Application No: Y/5/26/PL

Site Address: 2 Downview Road Yapton BN18 0HS

Description of works: Erection of terrace of 4 No town houses with gardens and parking spaces. This application is in CIL Zone 2 and is CIL Liable as new dwellings.

Thank you for your internet representation made on 17th March 2026 which has been recorded as an objection with the comments as follows:

2 Downview Road, Yapton : Proposed 4-unit 3-storey Terrace of 3-bedroom Dwellinghouses : PROPOSED SITE LAYOUT

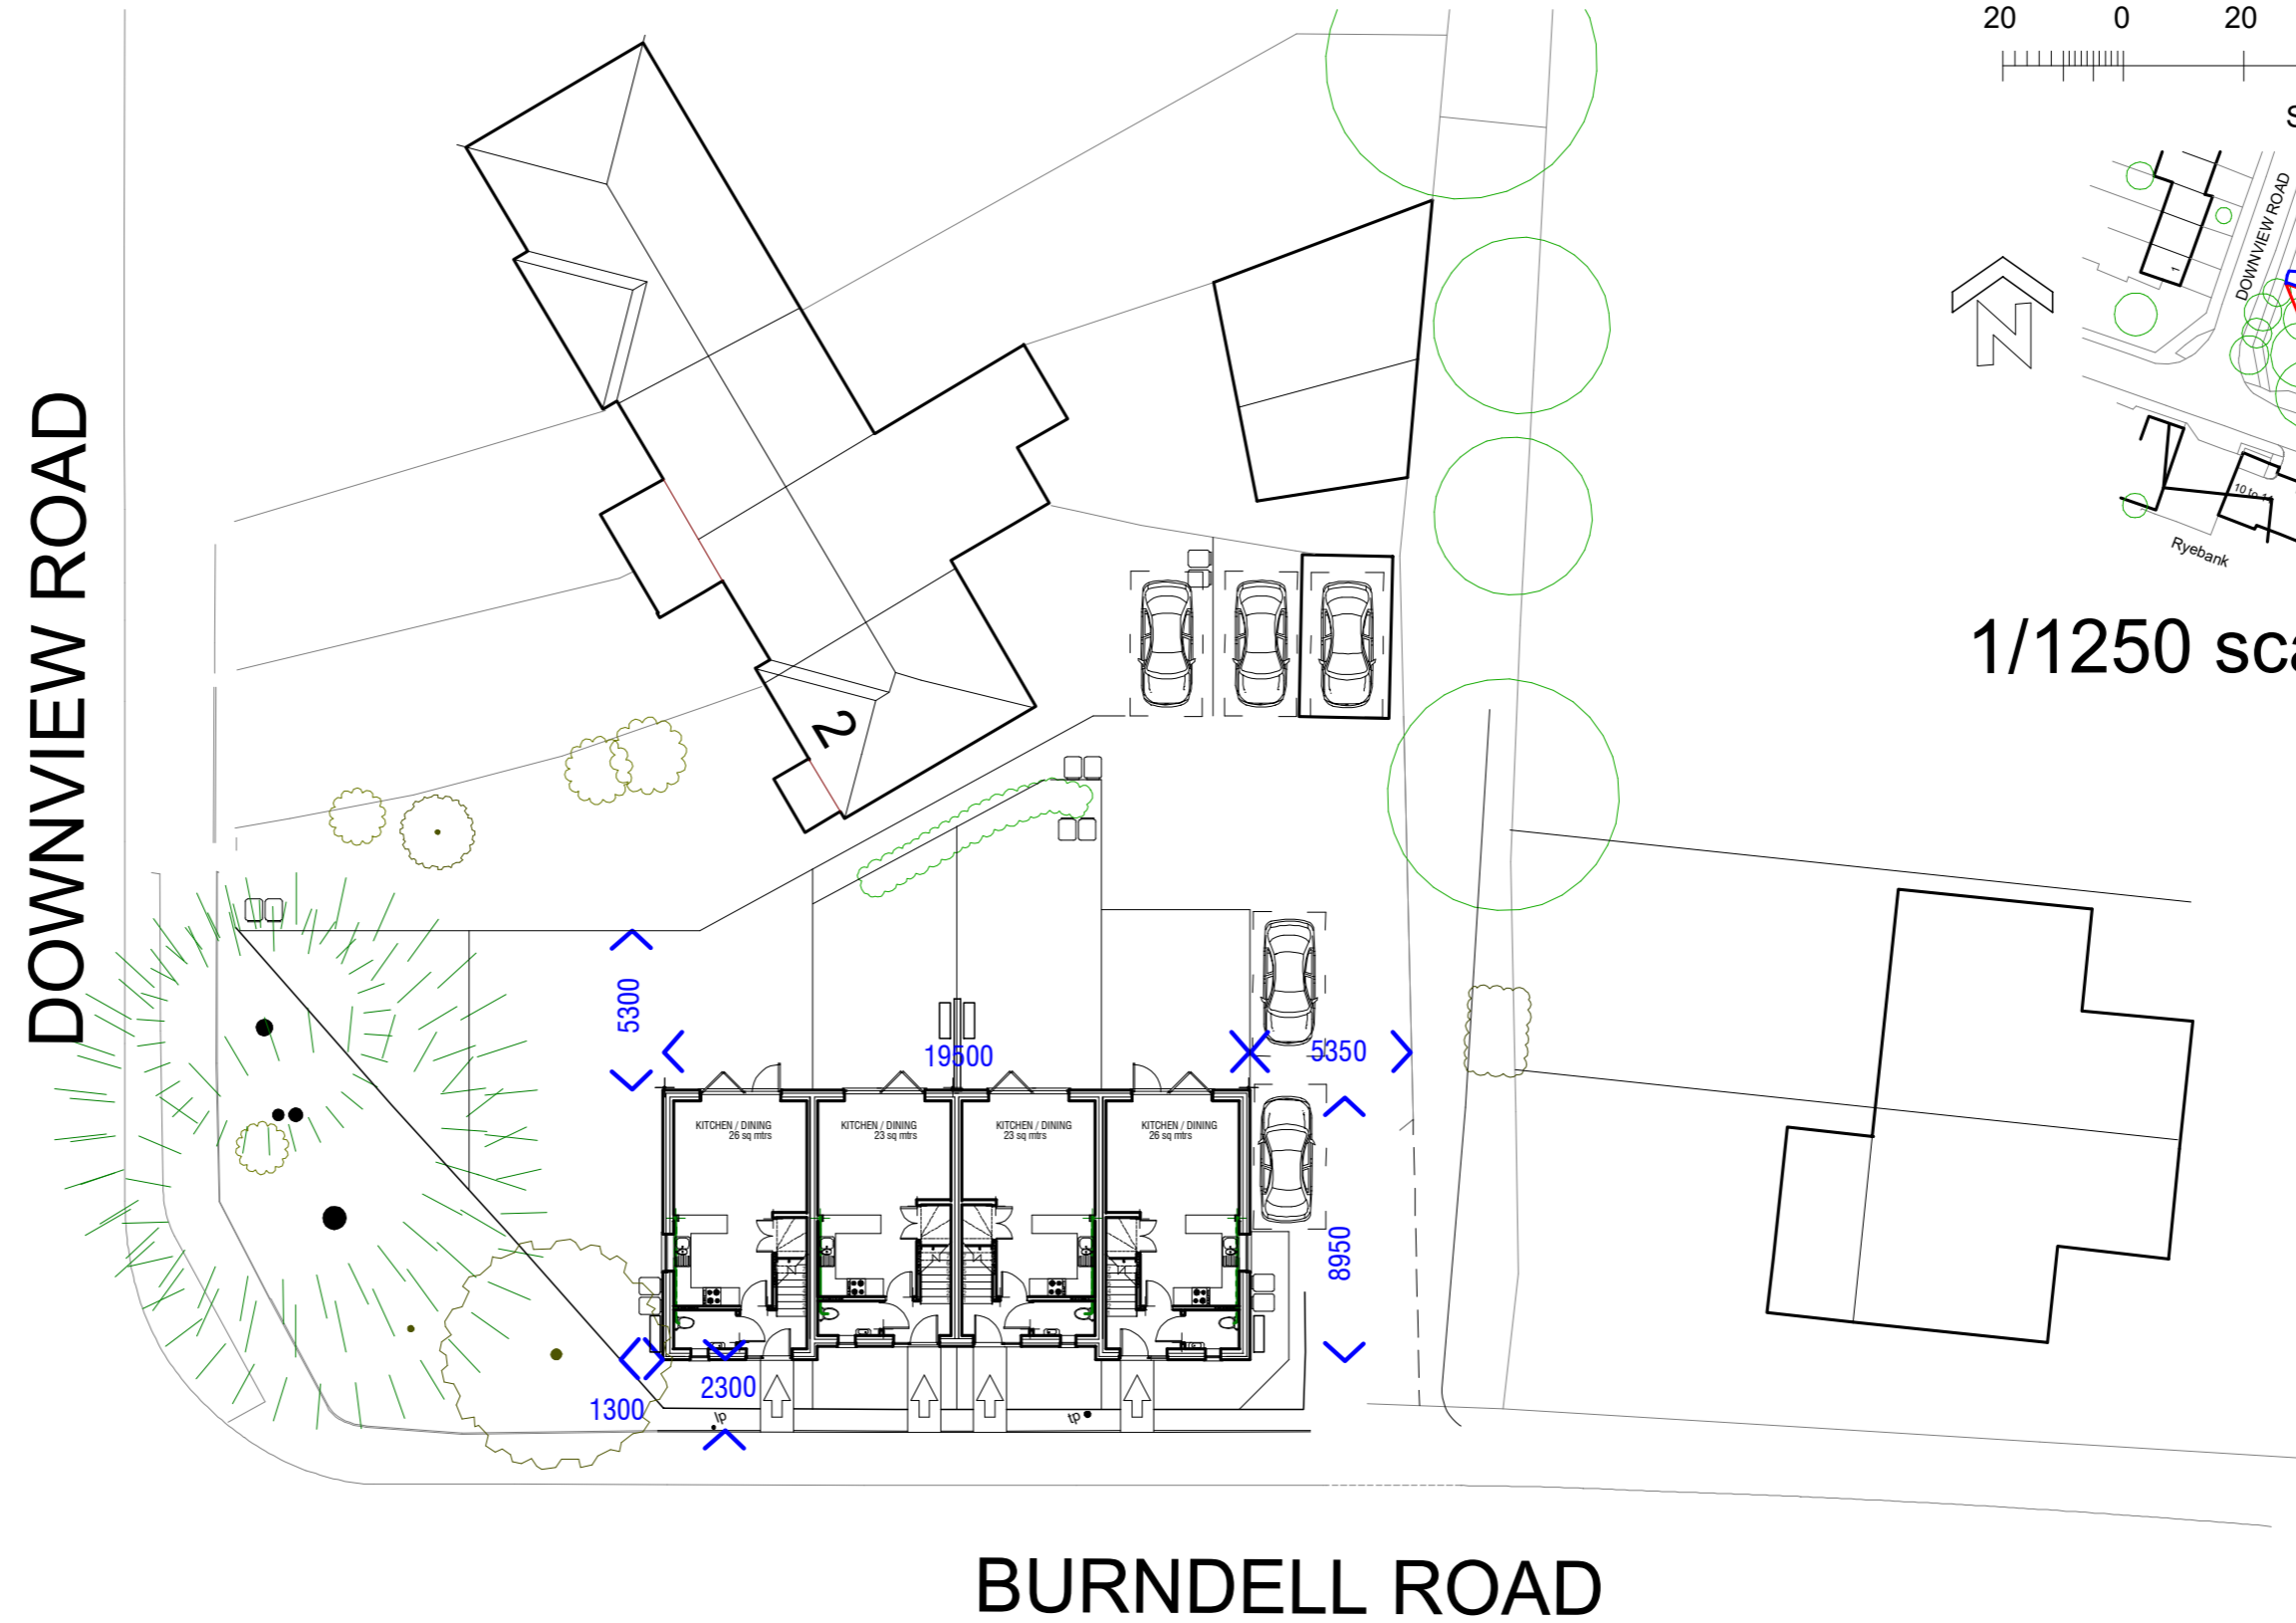
It should be noted that there is clear build line along this section of Burndell Road with all buildings on the northern side of Burndell Road being set back from the pavement by approximately 7.50m. This provides an essential open feel when approaching the village centre and green reflecting its past rural heritage. The proposed new terrace's build line reduces this build line to a mere 2.3m which will adversely impact the setting of this area and surrounding buildings.

YPC request that clarity of parking provision is made for both the existing dwelling and provision for the new dwellings. It would appear that parking provision is currently deficient.

YPC also have concerns with the potential conflict with pedestrians and cars around the proposed access/egress point. Pedestrians use the informal walkway to the east of the site to access FP200-2.

2 Downview Road, Yapton : Proposed 4-unit 3-storey Terrace of 3-bedroom Dwellingshouses :
PROPOSED ELEVATIONS and SECTIONS

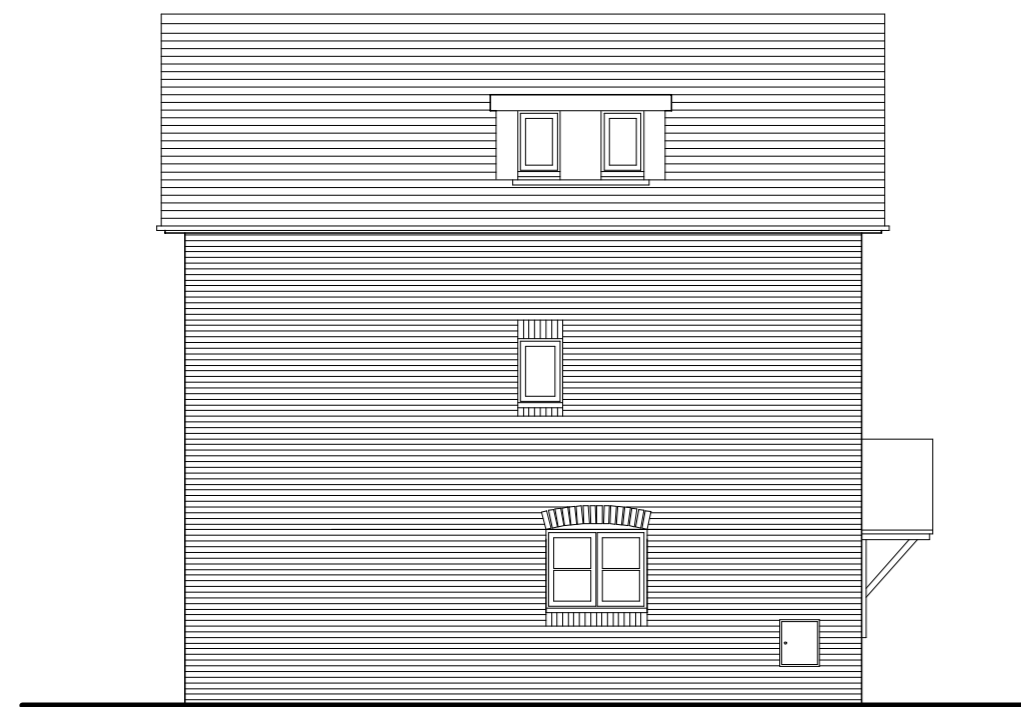
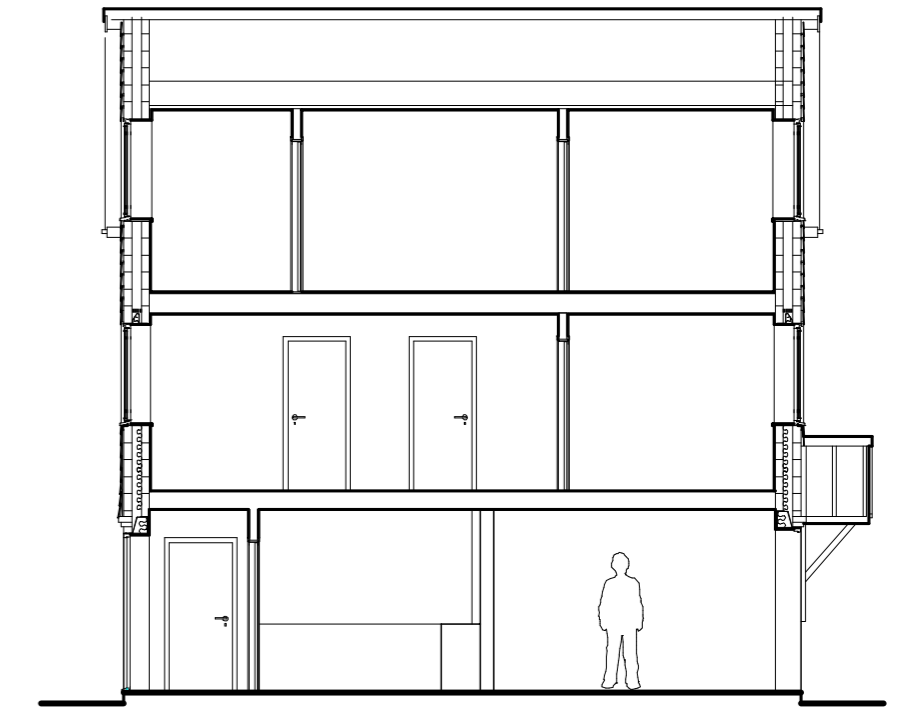
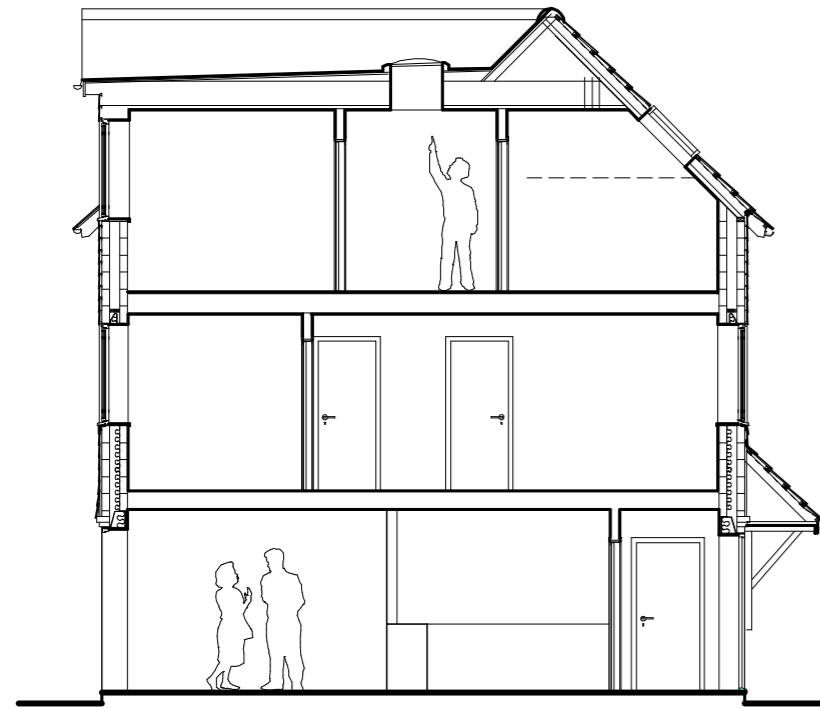
The height of the terrace is substantially higher than the existing buildings on the northern side of Burndell Road making it an inappropriate and disproportionate design for this section of Burndell Road and Downview Road. The proposal fails to blend and reflect the vernacular of the buildings north of Burndell Road. In fact the current proposal will be overbearing in relation to its neighbouring buildings and built form.
